RE: Staff Review Comments for Level III Preliminary Site Plan – Planning Board Review

Project Name: West End Place
Address: 40-44 Pine Street (183-189 Brackett Street)
Applicant: Redfern LWS, LLC
Planner: Shukria Wiar

Project ID: #2012-612
CBL: 45-E-39, 40,41,42,50

**EXISTING CONDITIONS, DEMOLITION, E&S PLAN**  
**WEST END PLACE**  
**BRACKETT STREET PORTLAND, MAINE**  
PREPARED FOR:  
**REDERN LWS, LLC**  
P.O. BOX 8816  
PORTLAND, MAINE 04101

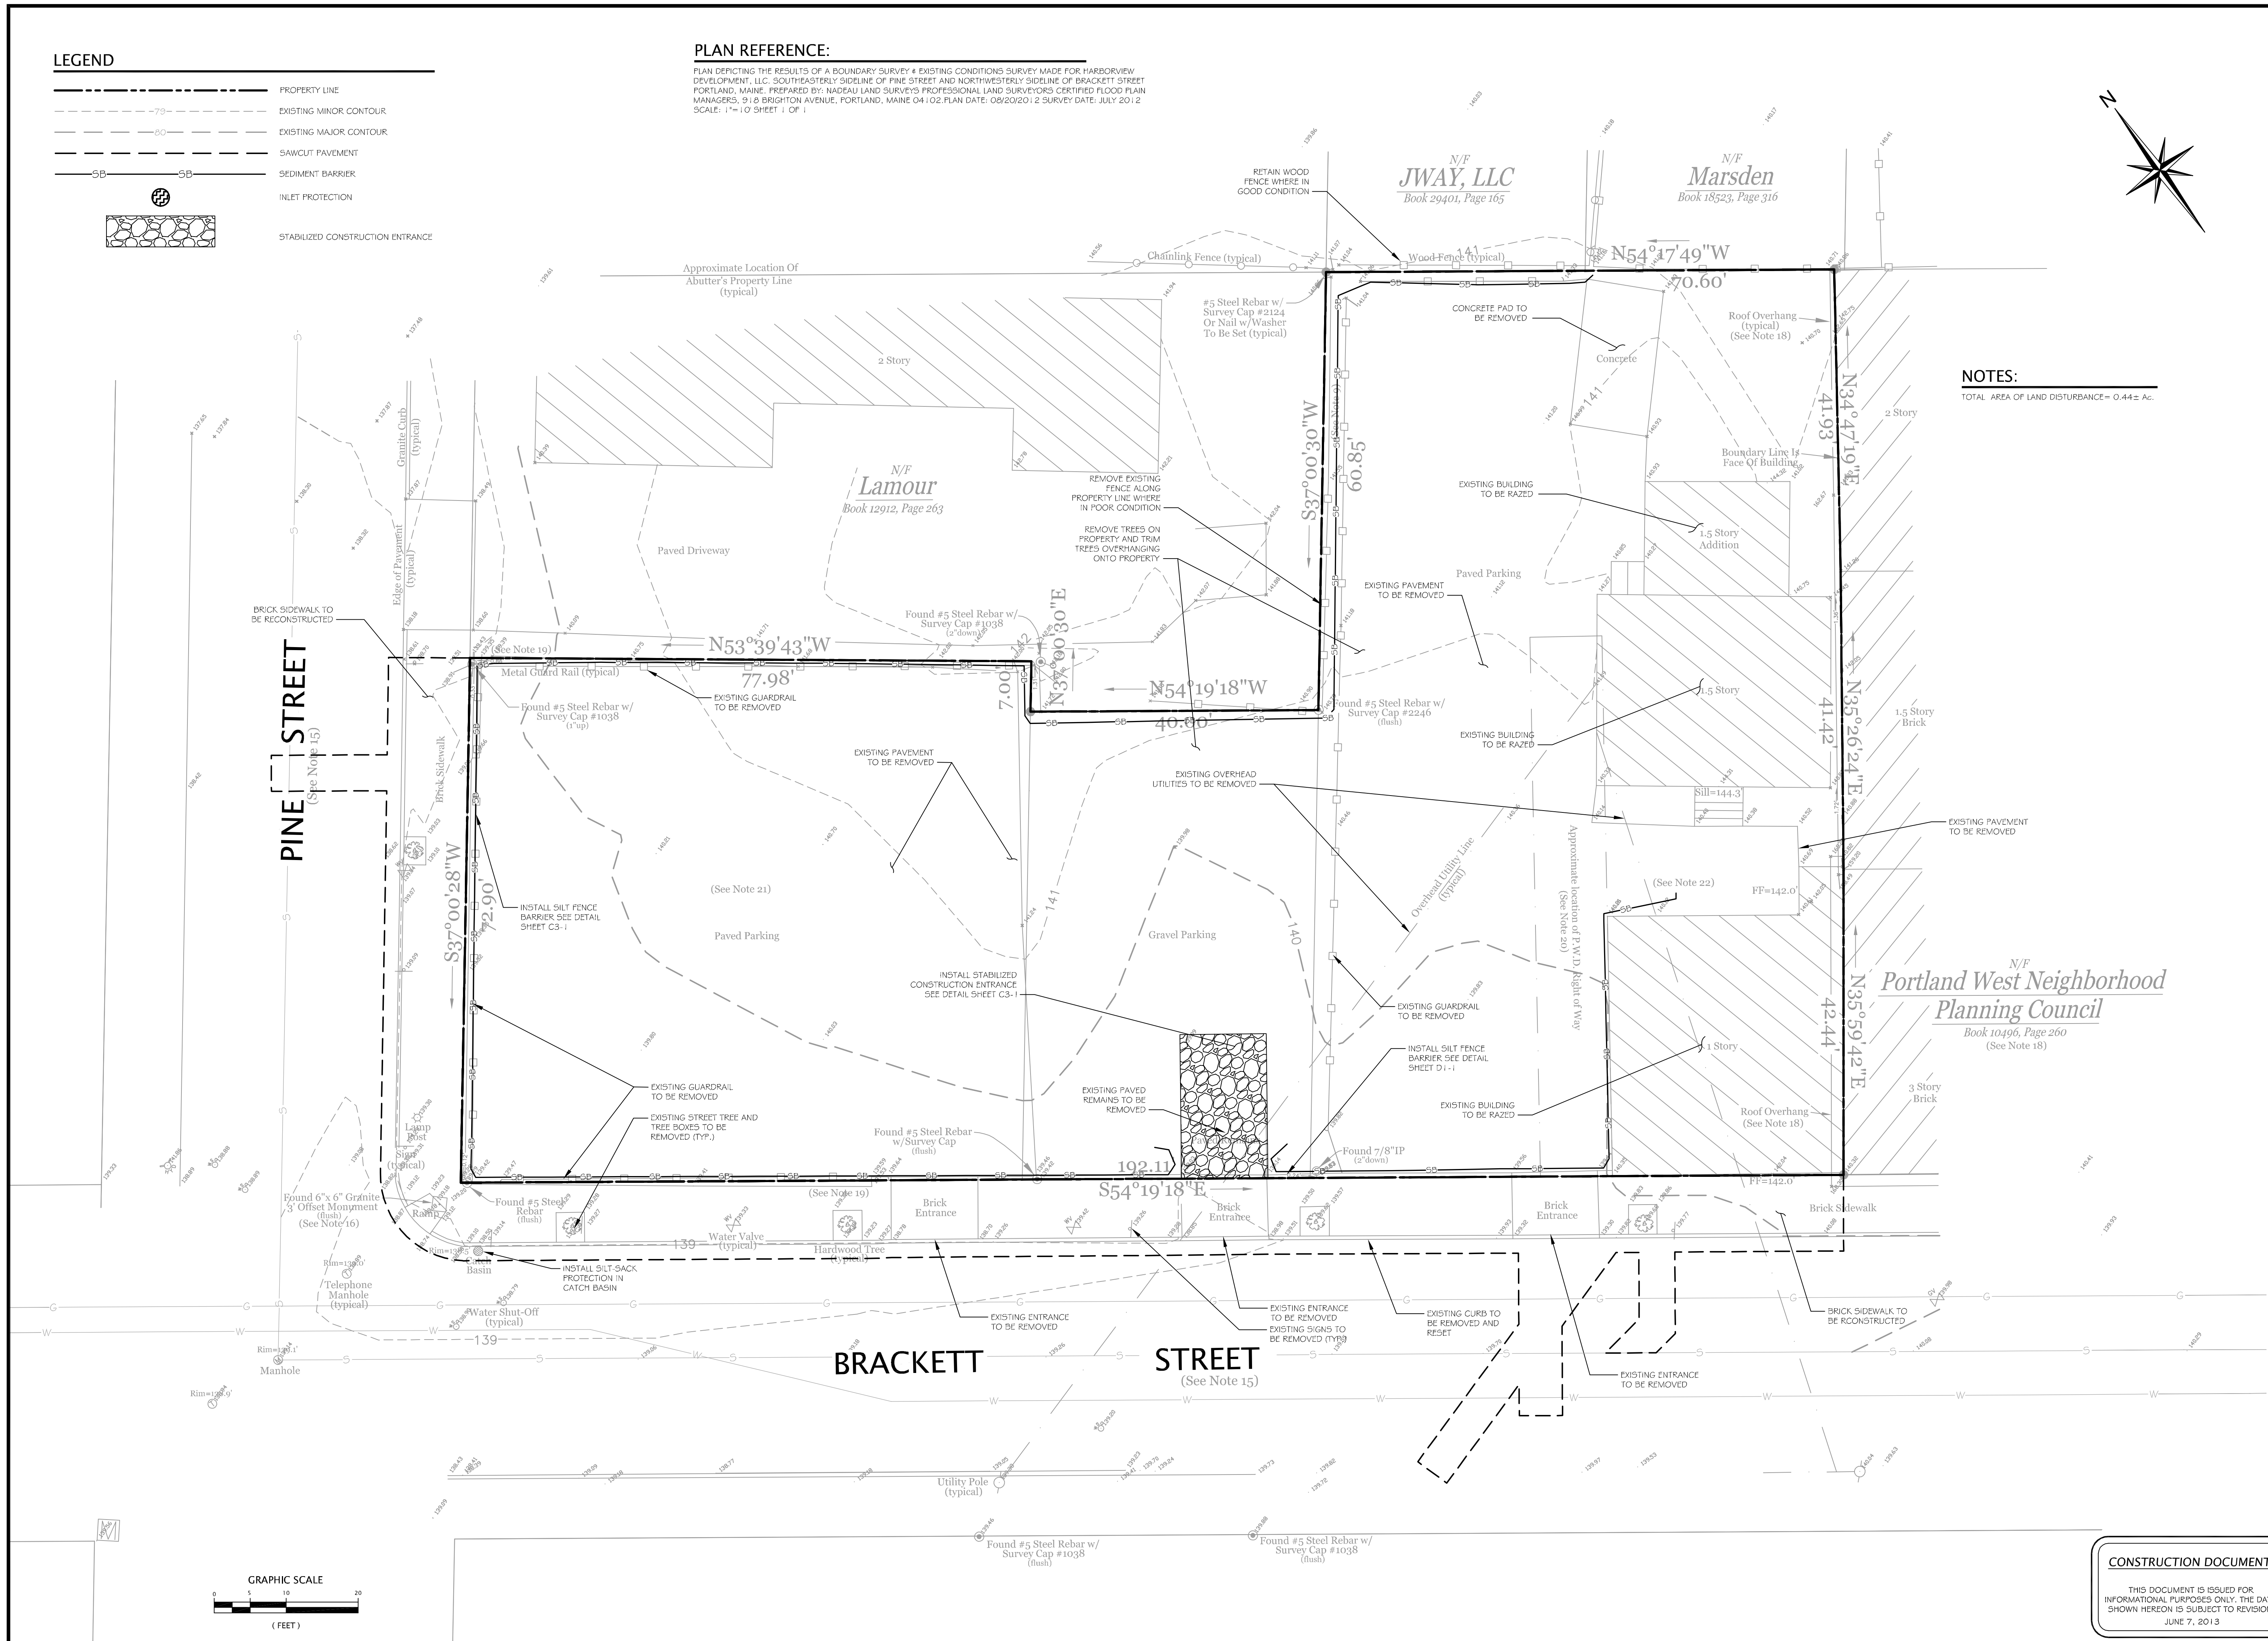
proposed a roof drain connection at the corner of Pine and Brackett Streets to an existing City of Portland catch basin and a storm drain connection to a new catch basin in Brackett Street. The Applicant should propose an alternate concept for these connections that is acceptable to the City Engineer.

- i. Basic Standards: Notes and details have been provided to address erosion and sediment control requirements, inspection and maintenance requirements, and good housekeeping practices in accordance with Appendix A, B, & C of MaineDEP Chapter 500. The proposed locations and/or methods of erosion control measures should also be indicated on the site plans.

FIRST FLOOR PLAN  
SCALE: 1/8" = 1'-0"

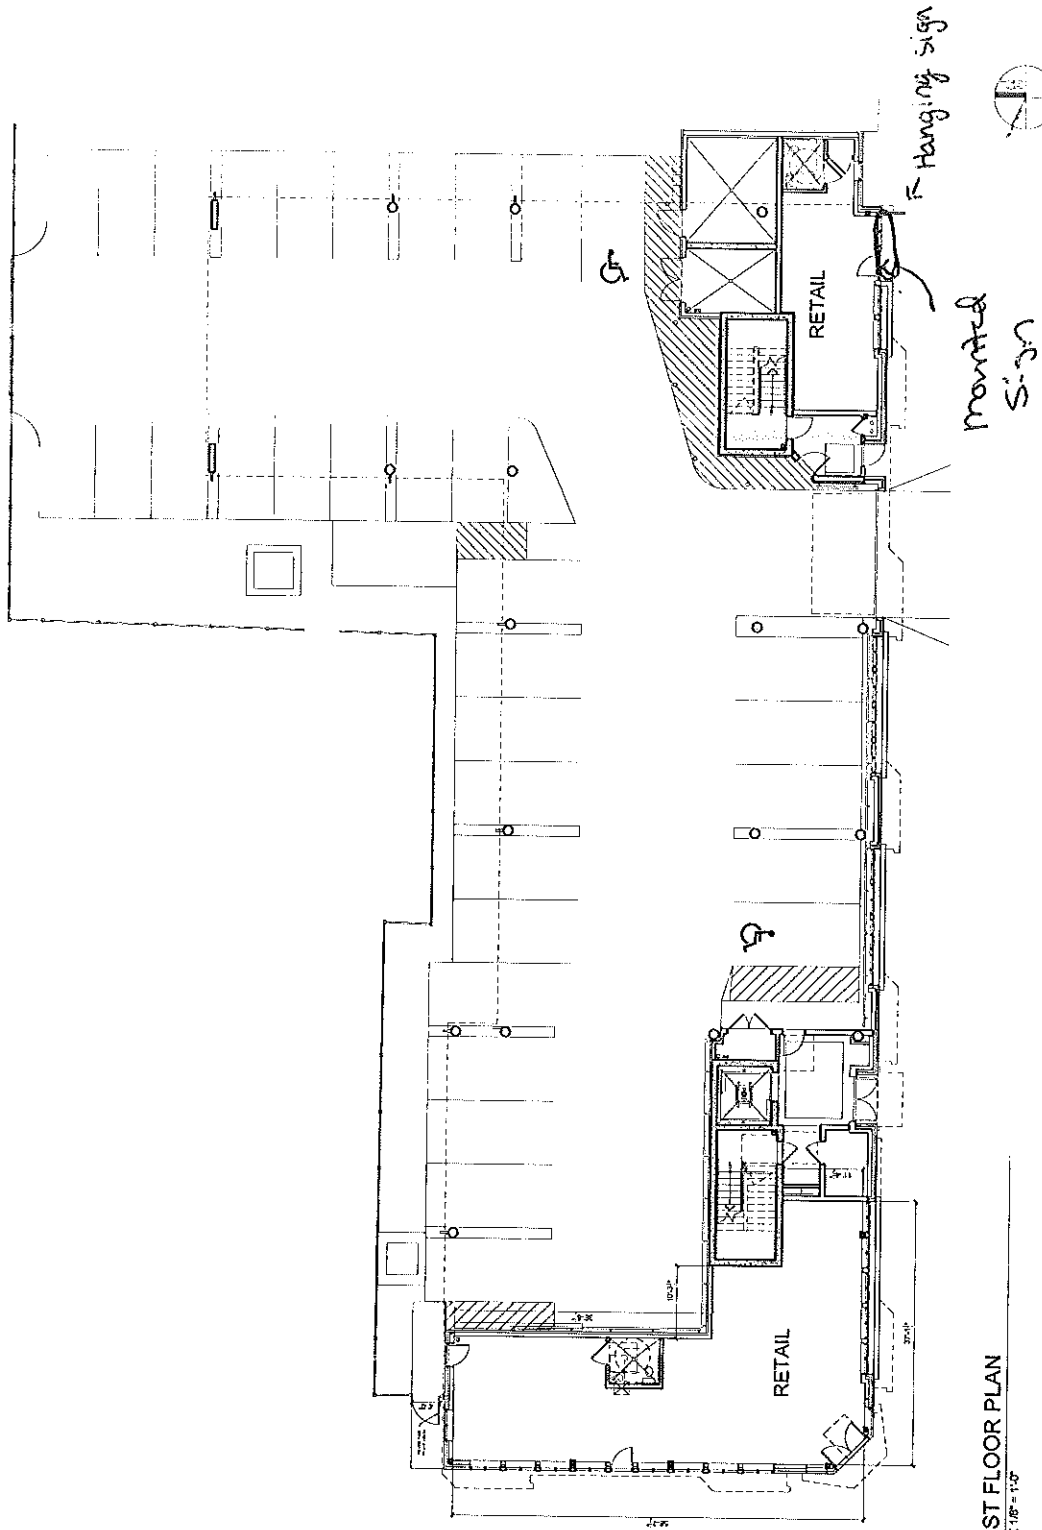
- f. The pavement markings delineating the no-parking areas at the driveway shall be removed.
- g. The parking lot layout does not meet City design standards for aisle width and the number of compact parking spaces. The applicant has provided vehicle turning templates that illustrates maneuvers into and out of parking spaces is possible. Given that the traffic volumes will be low and the applicant has provided evidence of a functioning garage, I support a waiver from the City's technical standards.

1. Please consider installing bike parking racks for four additional bikes in the sidewalk area. The proposed internal bike parking configuration does not allow for convenient access for parking of bikes. Consider different location or configuration.
